Application by Mr E Cattaneo

For Planning Permission for the erection of a garden building

63 Keldgate, Beverley, East Riding of Yorkshire, HU17 8HU

Application No 23/02999/PLF

Section A-A

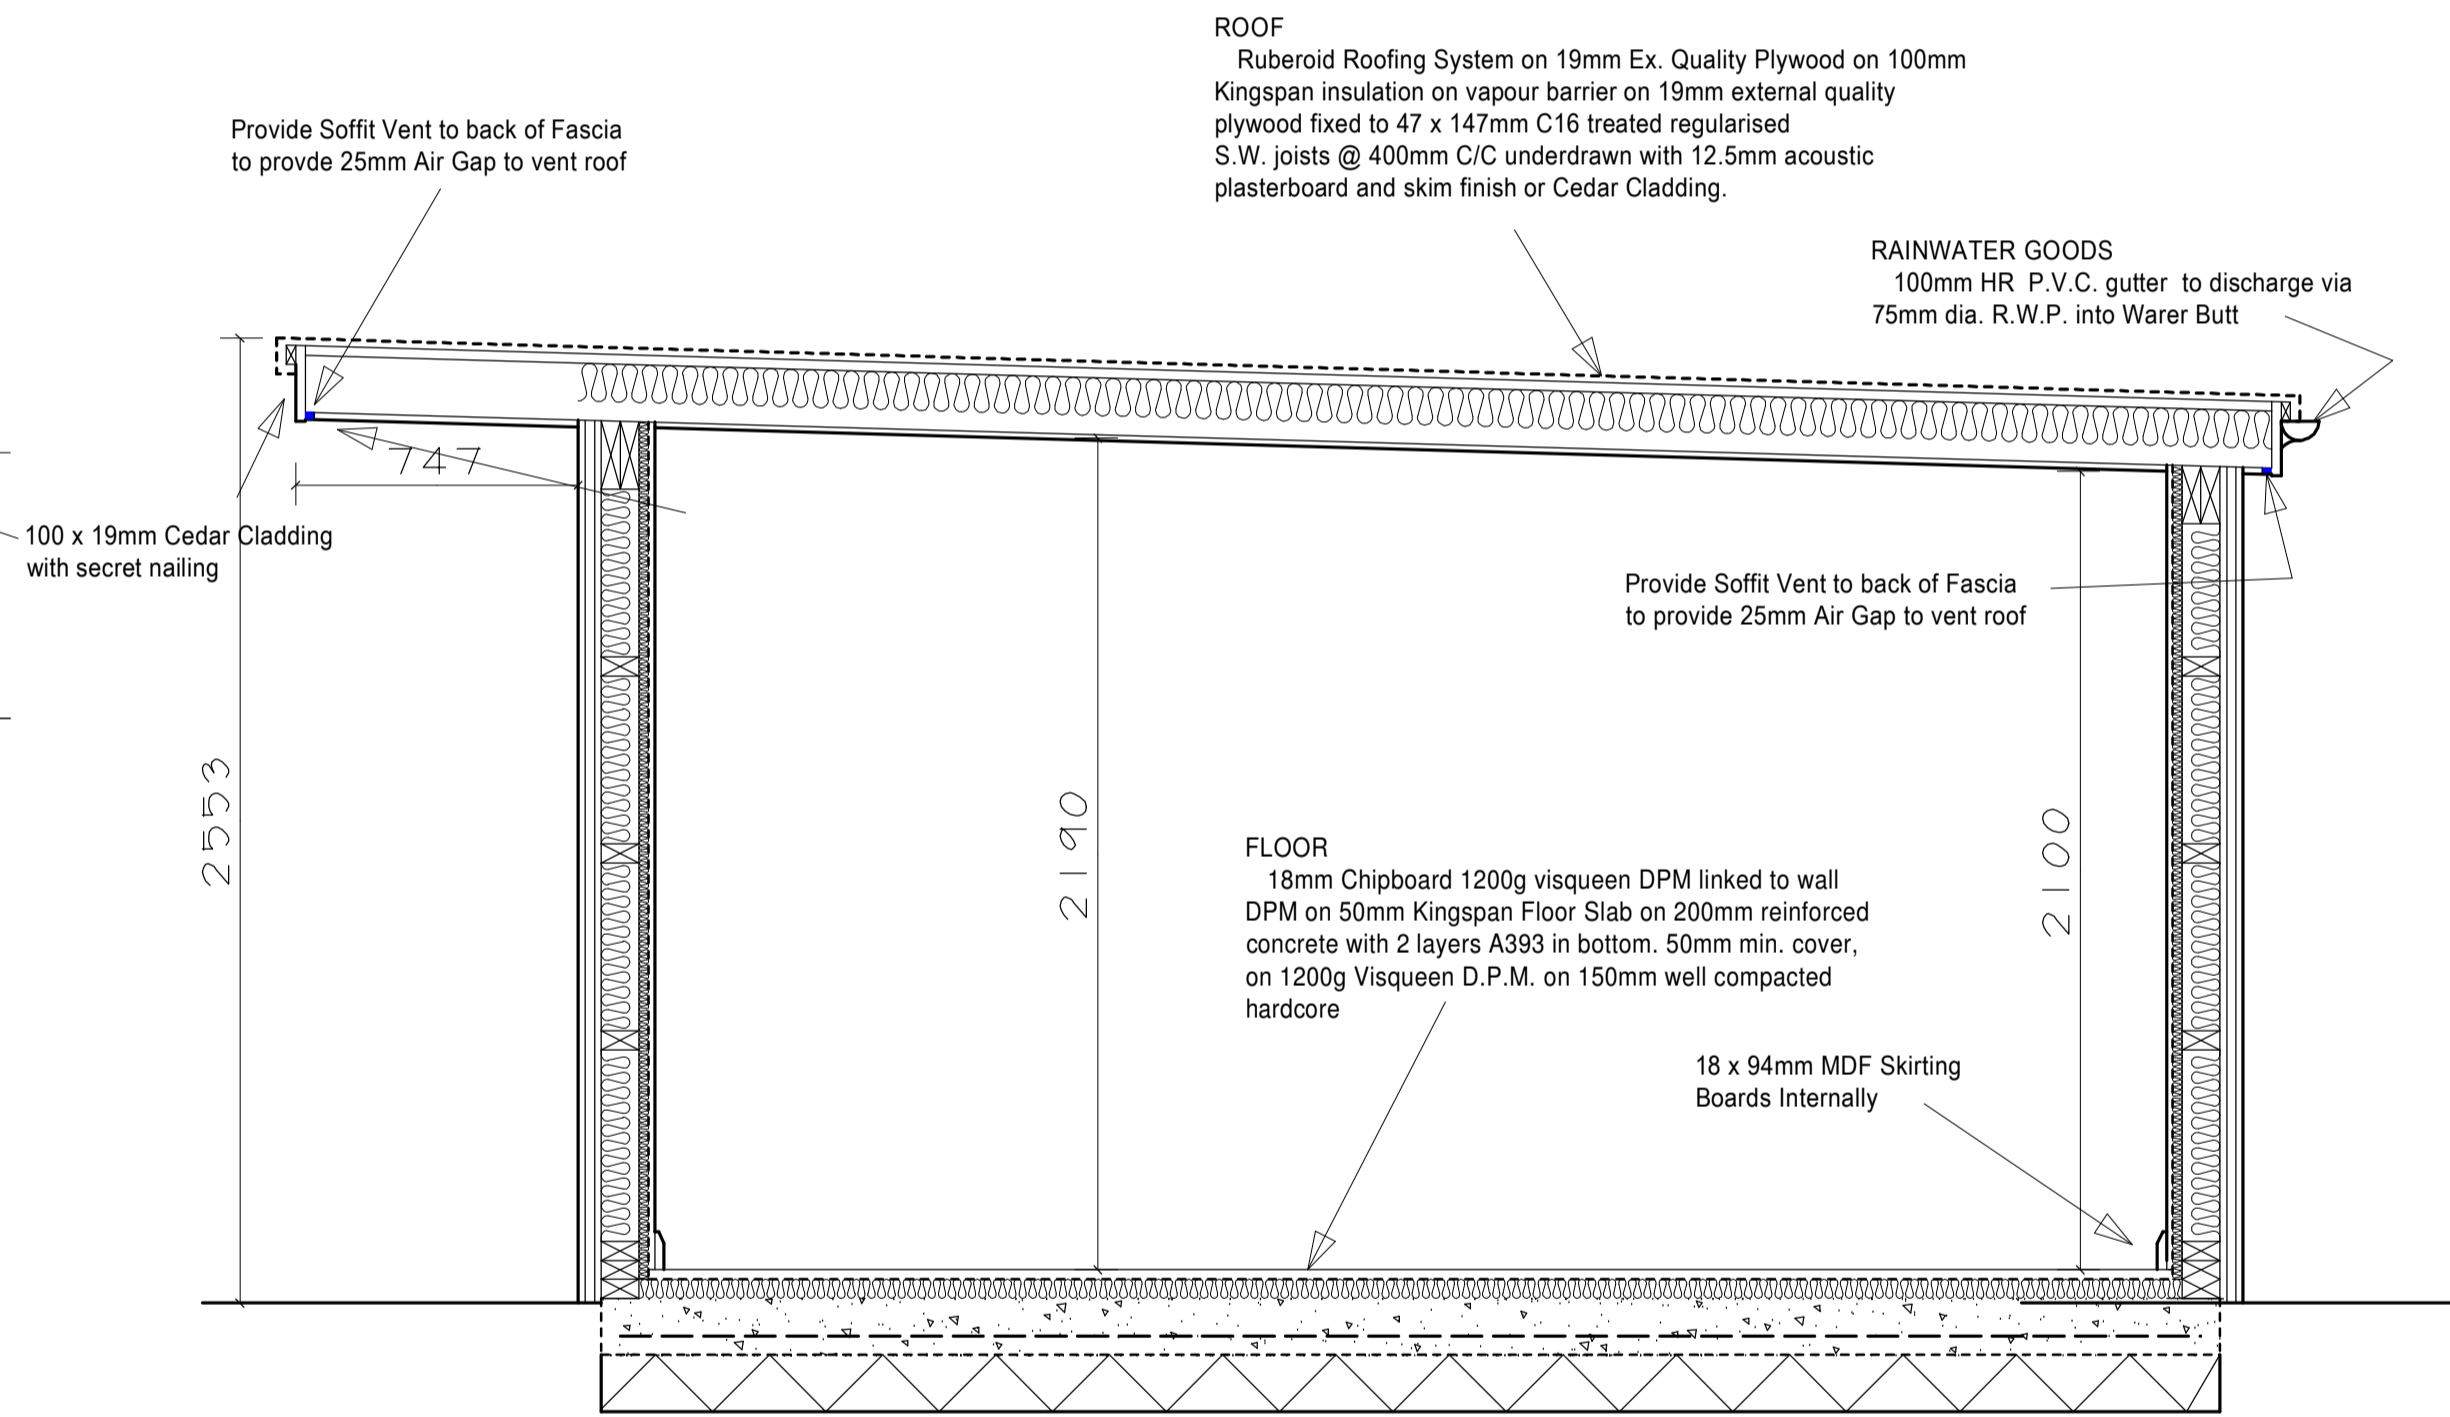
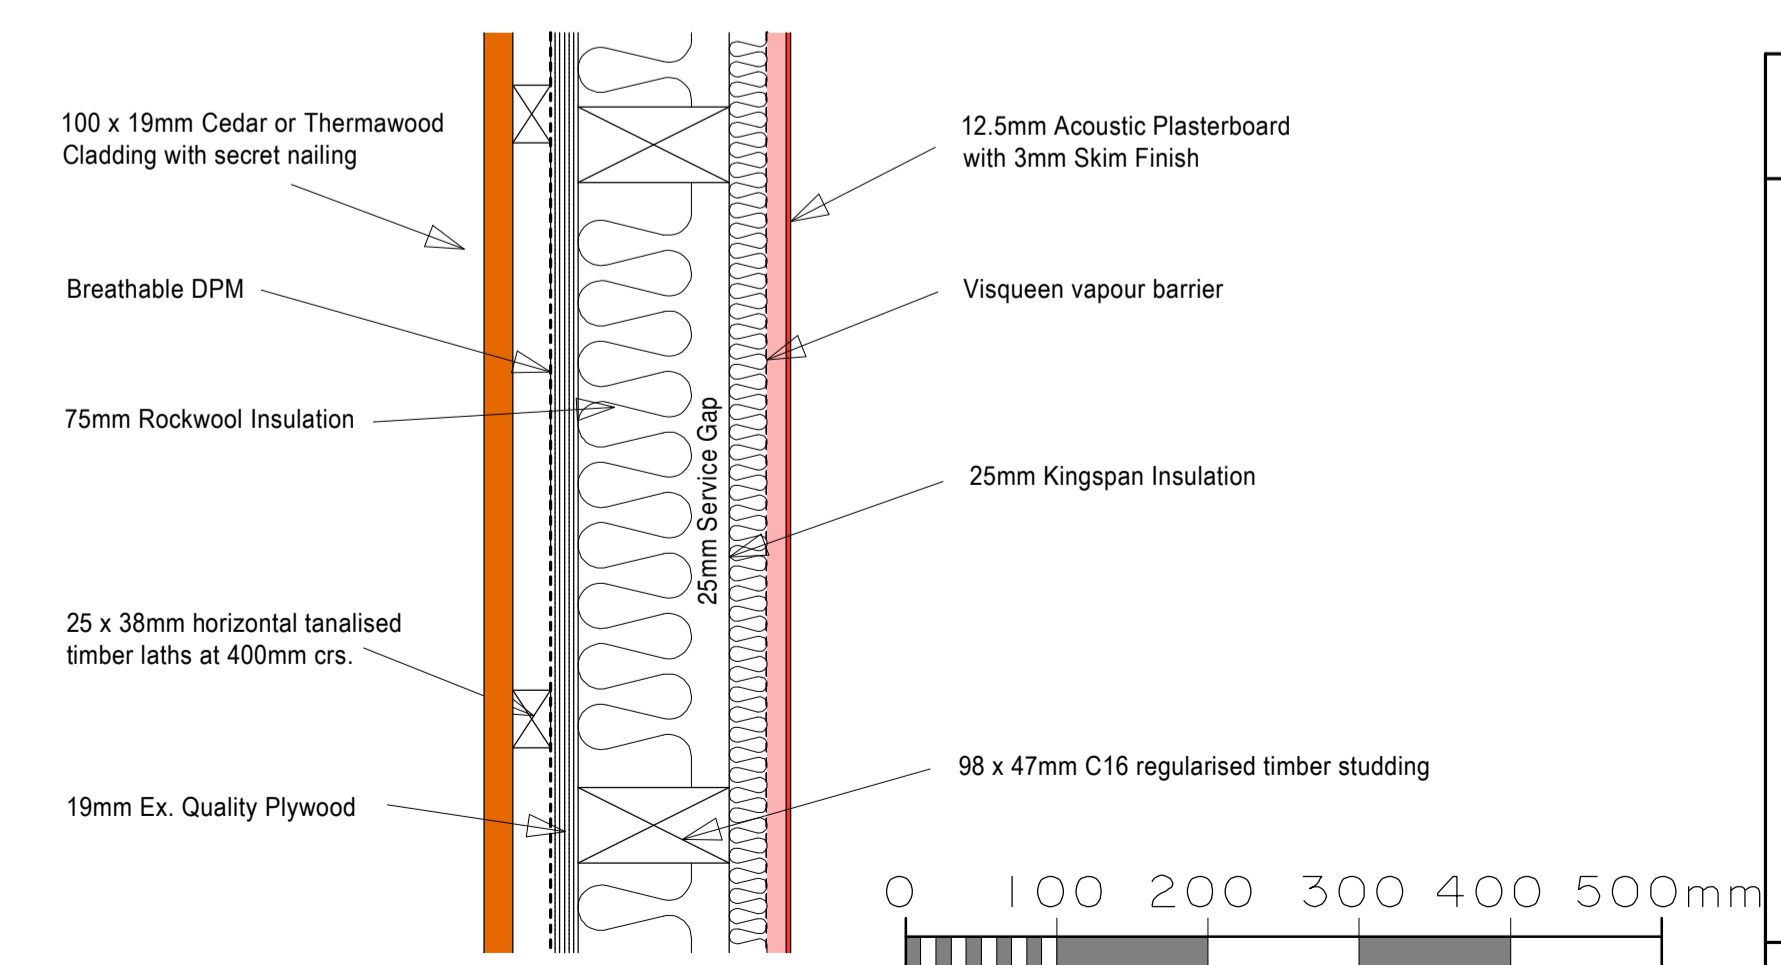
amend and ensure to include the overhang. Please provide an amended Proposed Site Plan as required.	
PROPOSED PLANS (4090/P9) - Please include a scale bar to a scale of 1:50 and 1:20 on the Proposed Plans.	Amended plan submitted
Please provide manufacturers details of the air conditioning unit as shown on the	Attached
LOCATION PLAN - Please note, I have amended the Location Plan to add 'Keldgate' to the road in front of the property.	Noted. However, the location plan was provided by the Planning Portal
